Planning Application Ref: BN/142/20/OUT

Location: Land south of Barnham Station, Barnham

Description of works: Outline planning application with all matters reserved, other than principal means of access, for up to 200no. dwellings, with access taken from Marshall Close, associated infrastructure & landscaping & demolition of existing buildings. This application is a Departure from the Development Plan, may affect the setting of listed buildings, may affect the Church Lane, Barnham Conservation Area & affects a Public Right of Way

1311.03

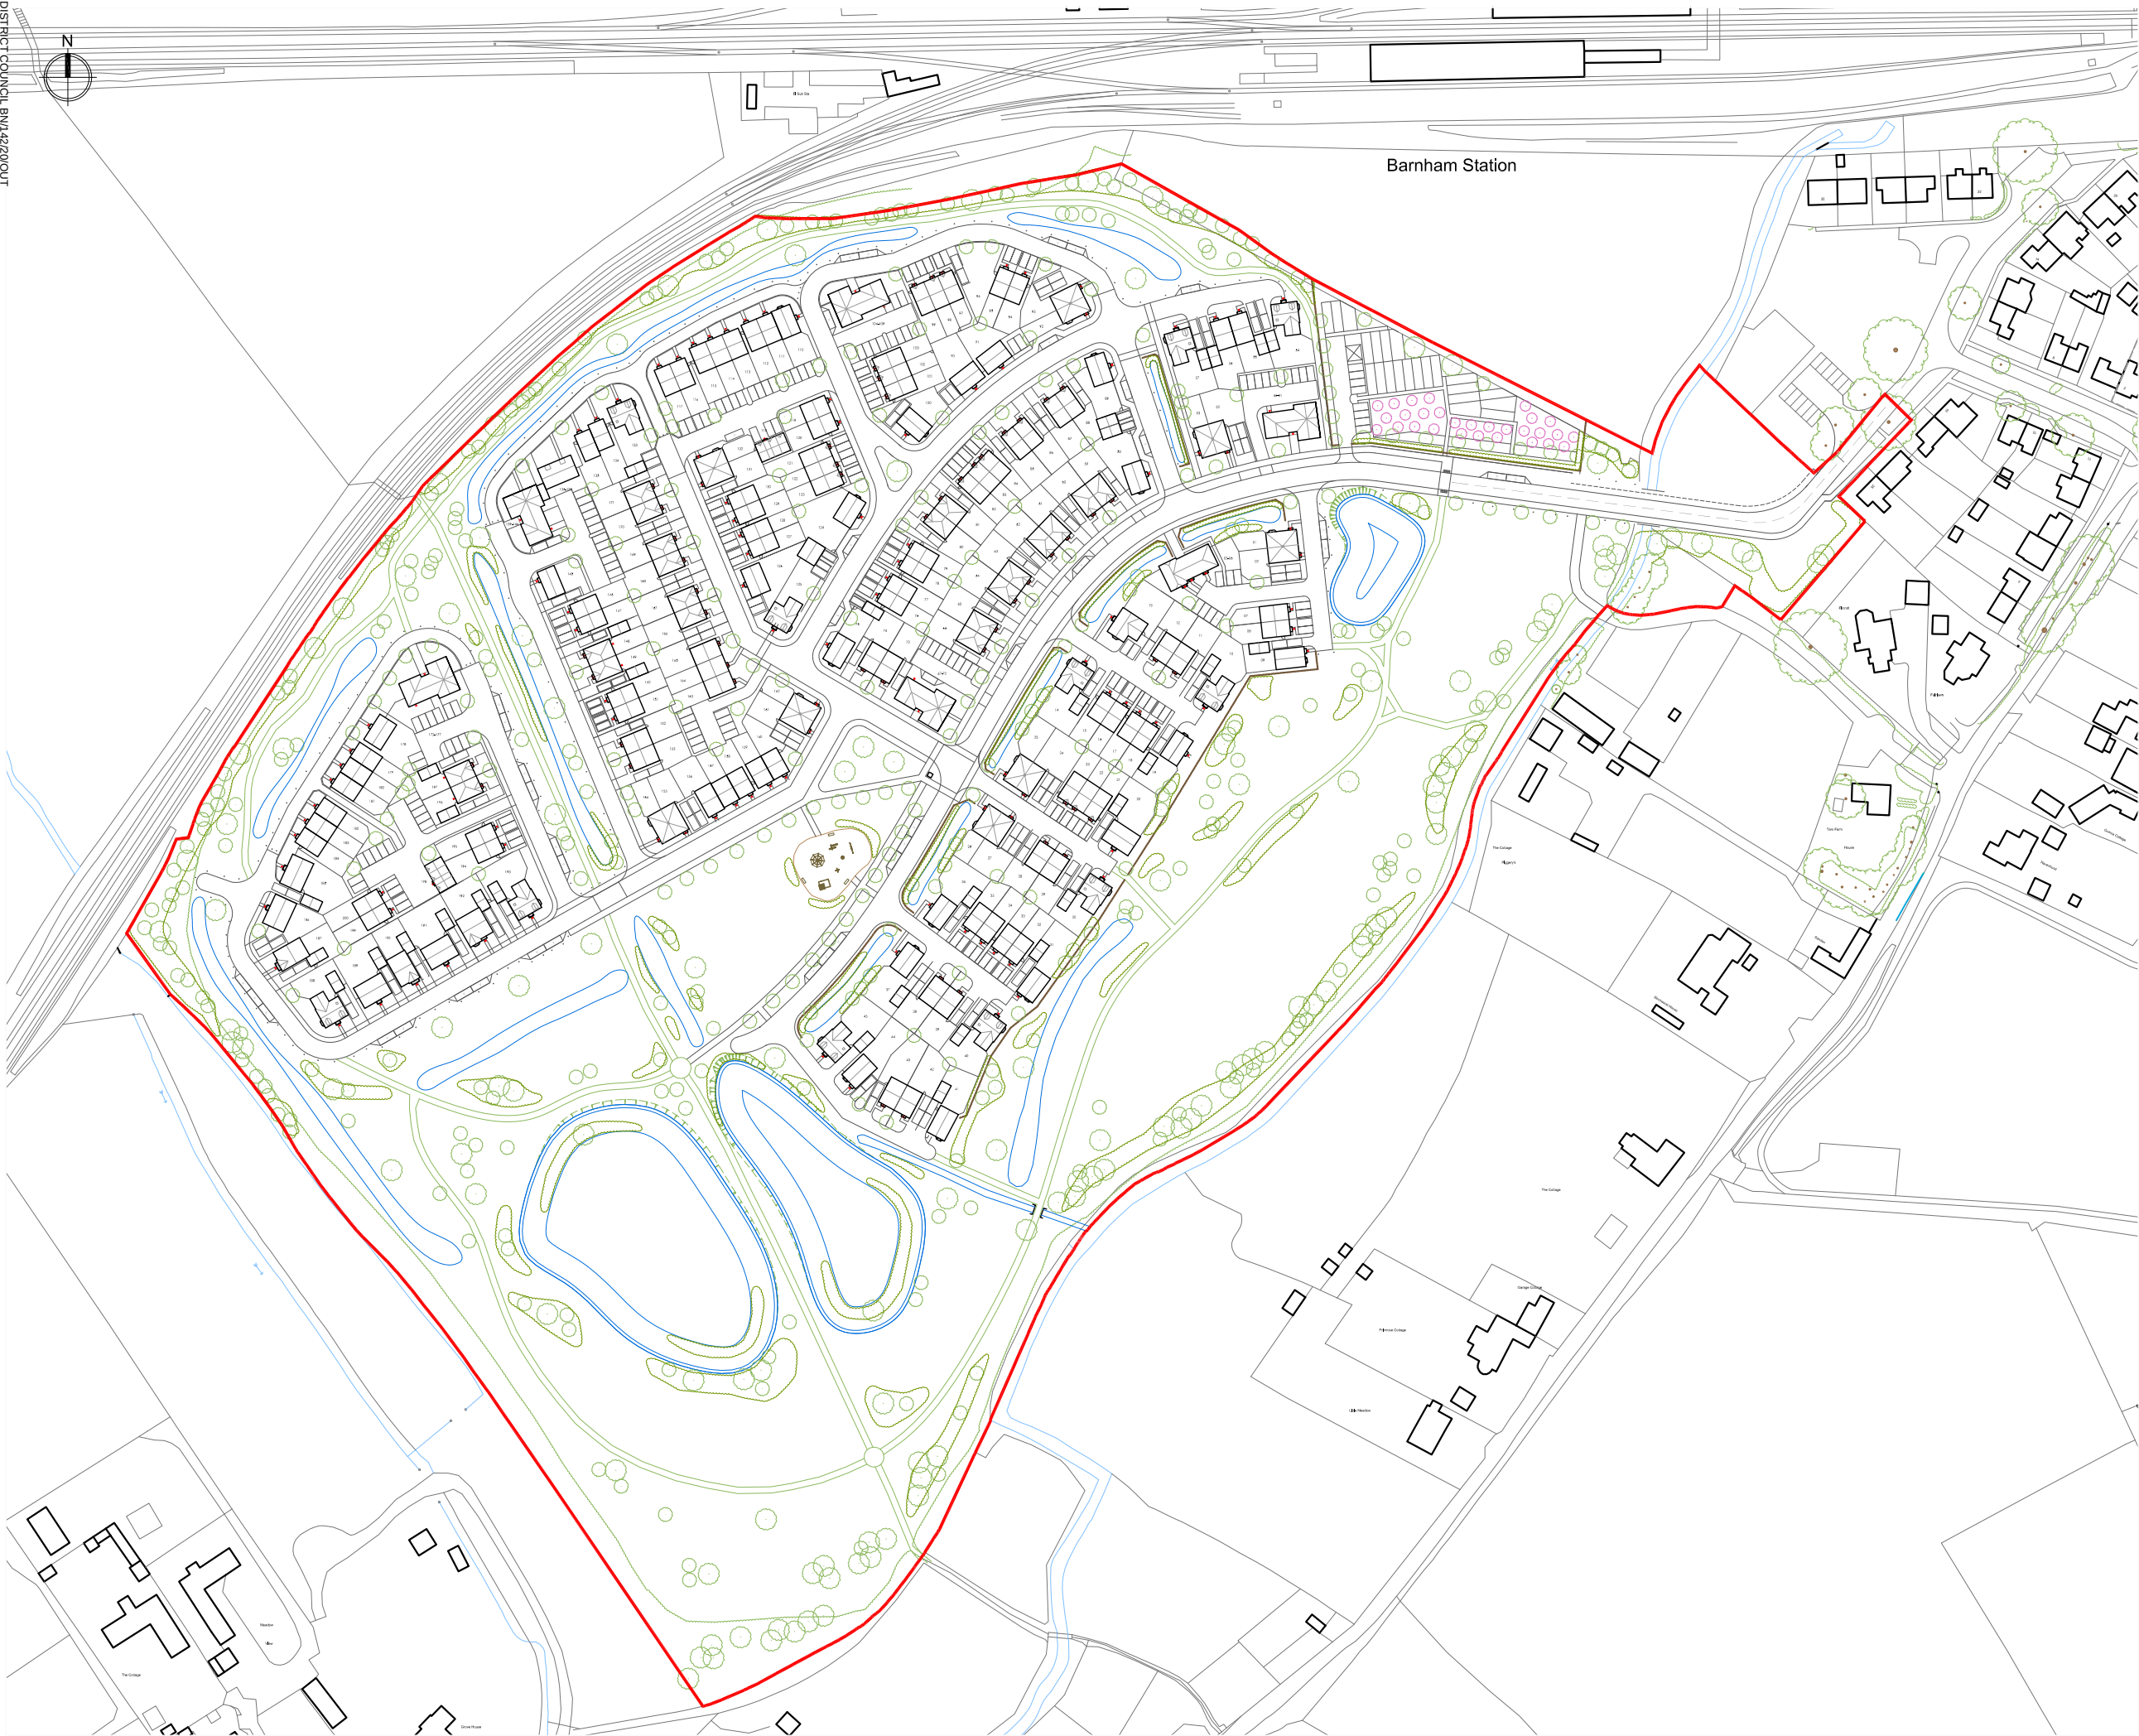
- In respect of Illustrative Site Layout Plan, dwg. ref. 1311.03., I make the following specific comments:
 - I defer to our Landscape and Leisure Officer in respect of how the site relates to the wider strategic housing allocation (SD5 - BEW) and ensuring green/blue infrastructure connectivity, enhancement of wildlife corridors and subsequent planting proposals – although am encouraged by the open space/above ground Suds features around the site and their relationship to higher value trees and hedgerow.

- I see no obvious problem with the proposed location of dwellings and the majority of associated infrastructure.
 - I am concerned about the approach to the site's main access, specifically in the absence of dwg. no. ITB14160-GA-010 which describes the highway improvements proposed for Marshall Close (as referenced within submitted plan from i-Transport, dwg. no. ITB14160-GA-005, Rev C). WSCC Highways Authority in their report of 16th December 2020 state that off-carriageway laybys are proposed to assimilate the existing on-road parking and thus allow adequate space for passing vehicles. A large, mature tree (T43 beech - Category A) of high public amenity value with correspondingly large nominal *root protection area* (RPA) looks vulnerable at this stage, in the absence of a scheme showing provision of laybys outside of both the crown spread and RPA.

- Furthermore, I would like to be reassured that the mature tree (T49 beech - Category A), similarly of high public amenity value (also outside of the site boundary shown red, yet possibly within the application area) growing on island verge at the junction of Church Lane and Yapton Road, will not be affected by any enhancement of the public highway deemed necessary to meet the additional traffic demands associated with this development proposal.

- The principle of development and access as described is certainly achievable without undue detriment to retained trees. The Illustrative Site Layout is encouraging from an arboricultural perspective, no doubt informed by the quality submission from the project arboriculturist. Should any substantive evolution of layout proposals occur, we should expect the design team to uphold the higher-level development principles promoted within our Supplementary Planning Documents: Arun Design Guide (emerging) and Arun District Public Open Space, Playing Pitches and Built Facilities.
- I register an **Objection** to these outline proposals on arboricultural grounds, due to the lack of information in support of proposed highway enhancements which are or may be necessary outside of the site boundary shown red and which could have a detrimental effect on trees of high public amenity value.
